Subject: FW: app3/2017/0184 Wilkin Square

Subject: app3/2017/0184 Wilkin Square

Proposed Site Plan

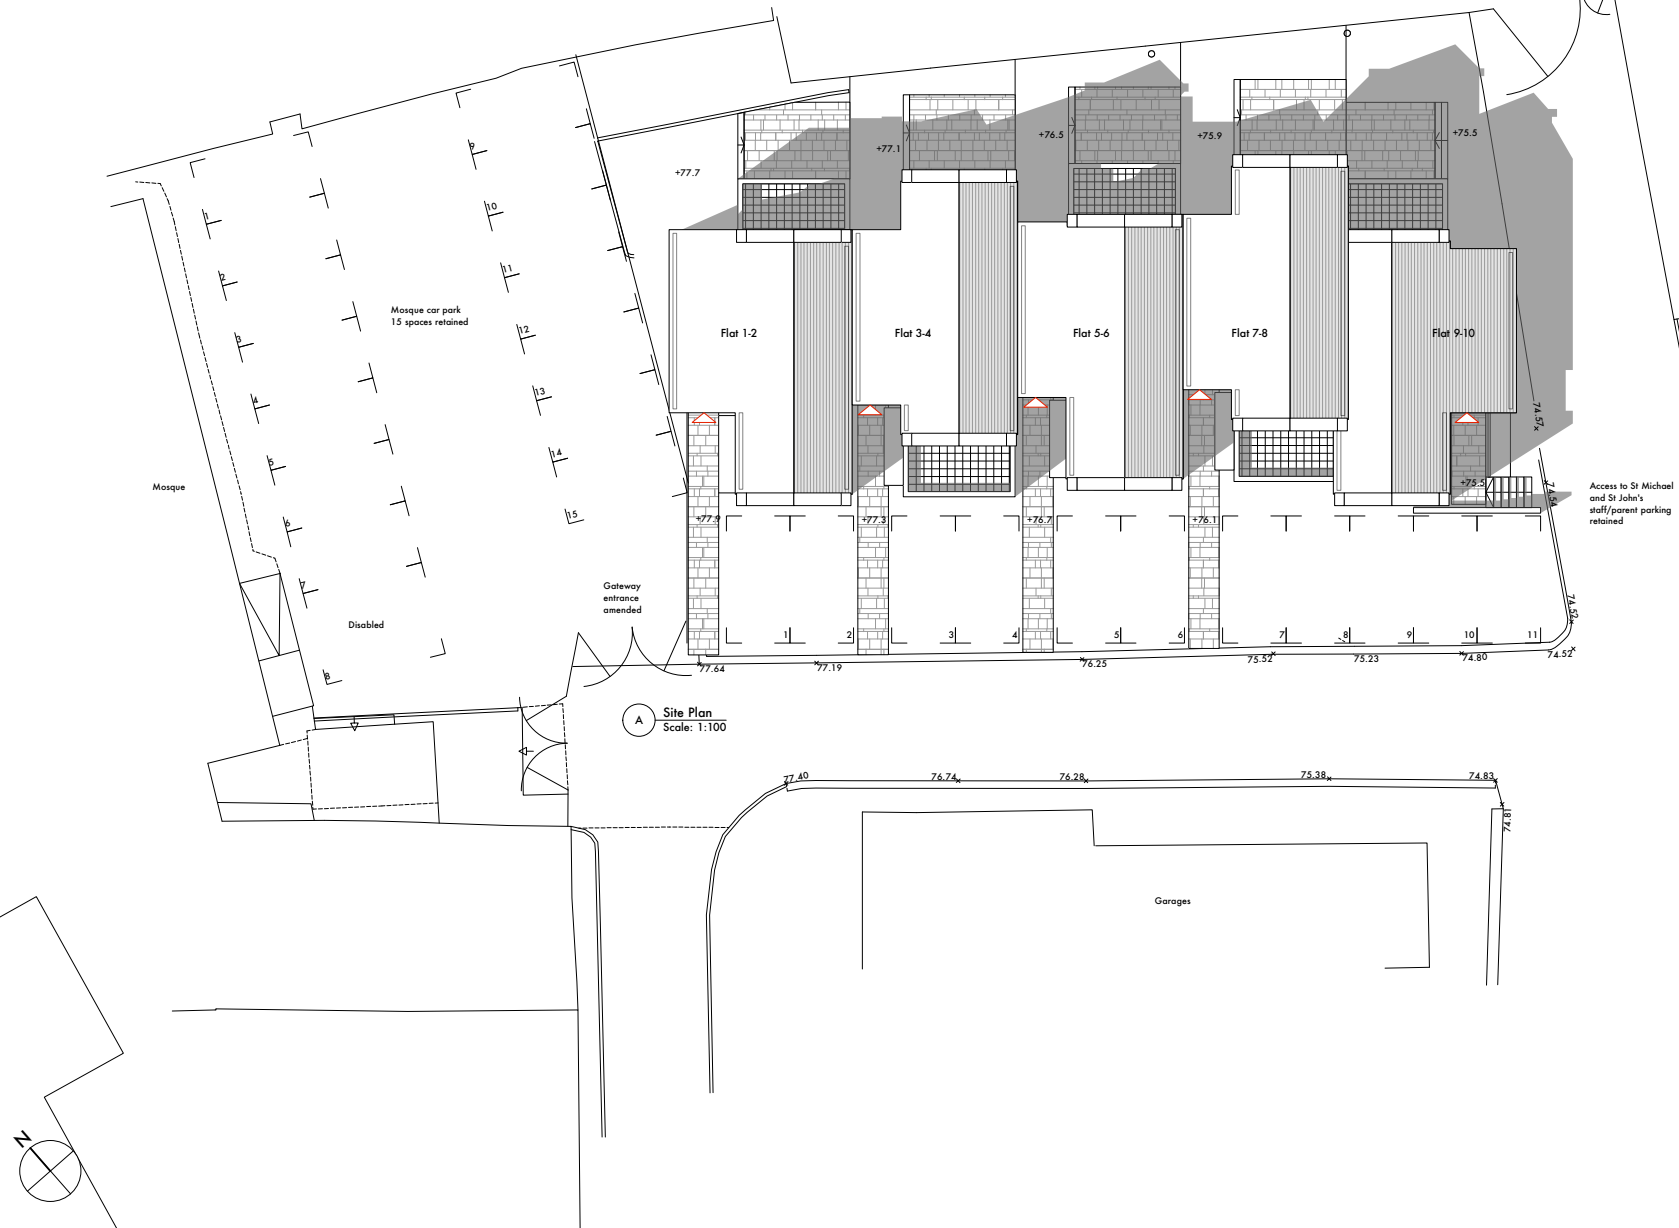
I refer to our recent conversation regarding the reversing distance afforded to the proposed development parking spaces. Ideally we would normally require a minimum distance of 6m to allow the completion of a reversing manoeuvre without causing delay to passing traffic. The available reversing distance is 5.3m which is below this requirement however I am mindful of the difficulties in repositioning the buildings and in view of the lightly trafficked nature of Wilkin Square I would reluctantly accept the proposal as presented.
